NSW Rural Fire Service

EAST ELEVATION

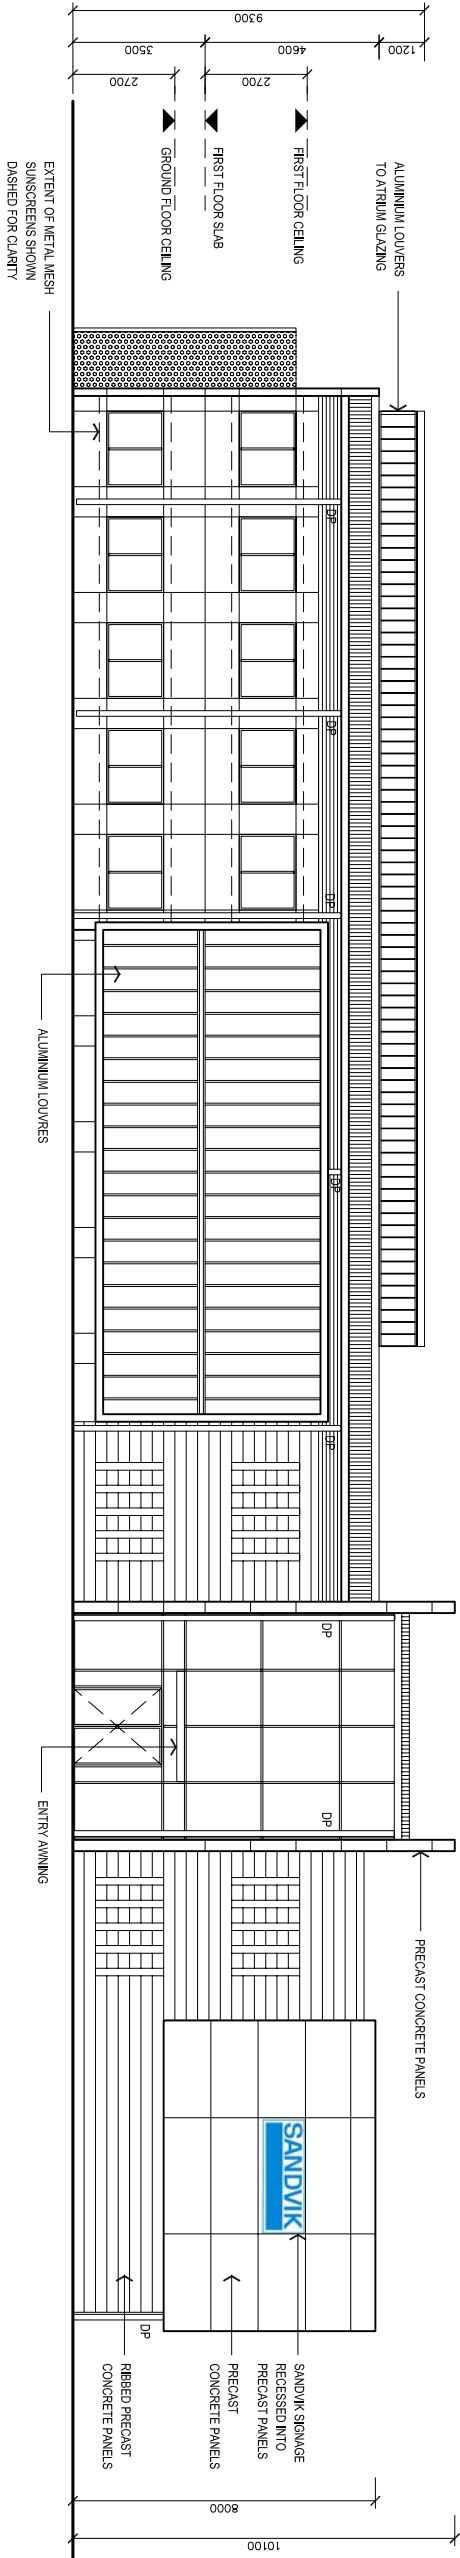
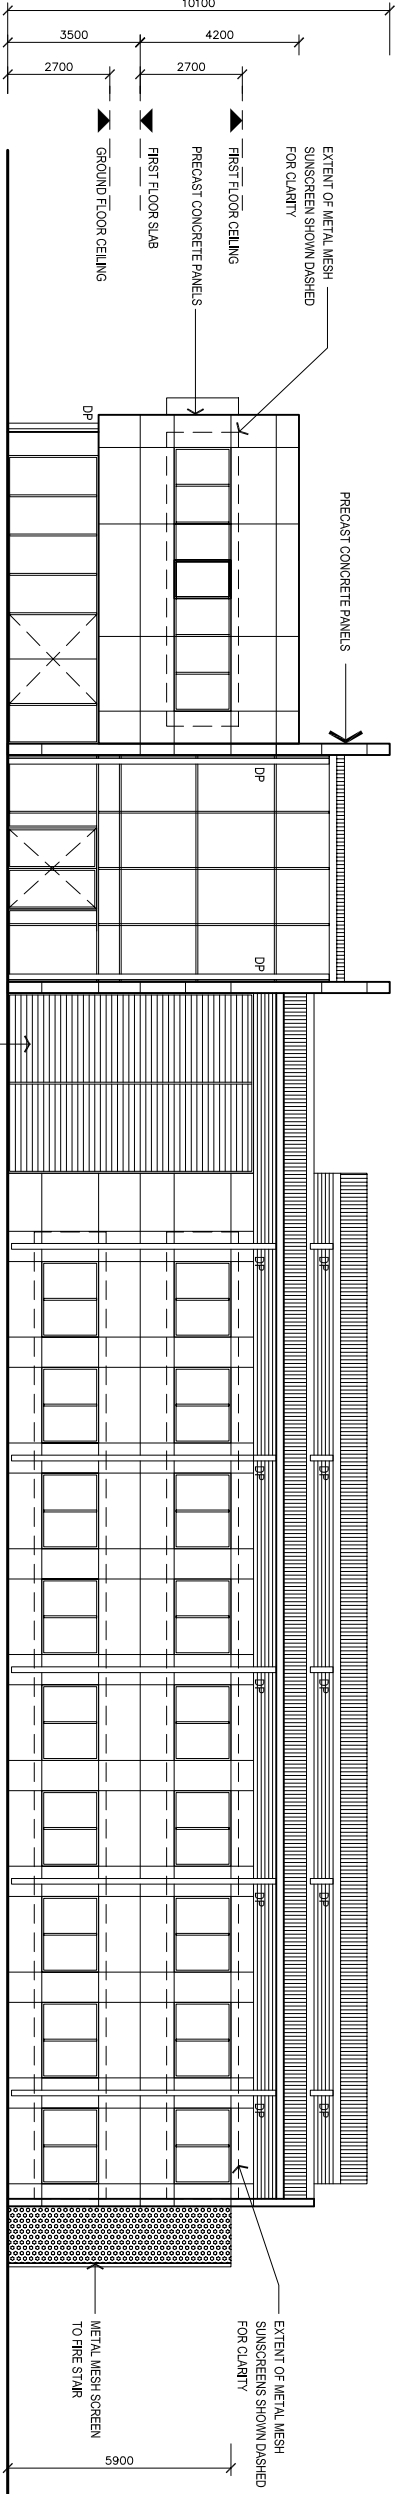
It is of concern that this project may be approved and a building constructed (I assume a two storey building) without offering the public the opportunity to view and comment on the appearance/scale of the buildings.

The proposed office building is two storeys in size and is of similar scale to the other proposed buildings on site. Additional copies of the elevations of the proposed office are provided.
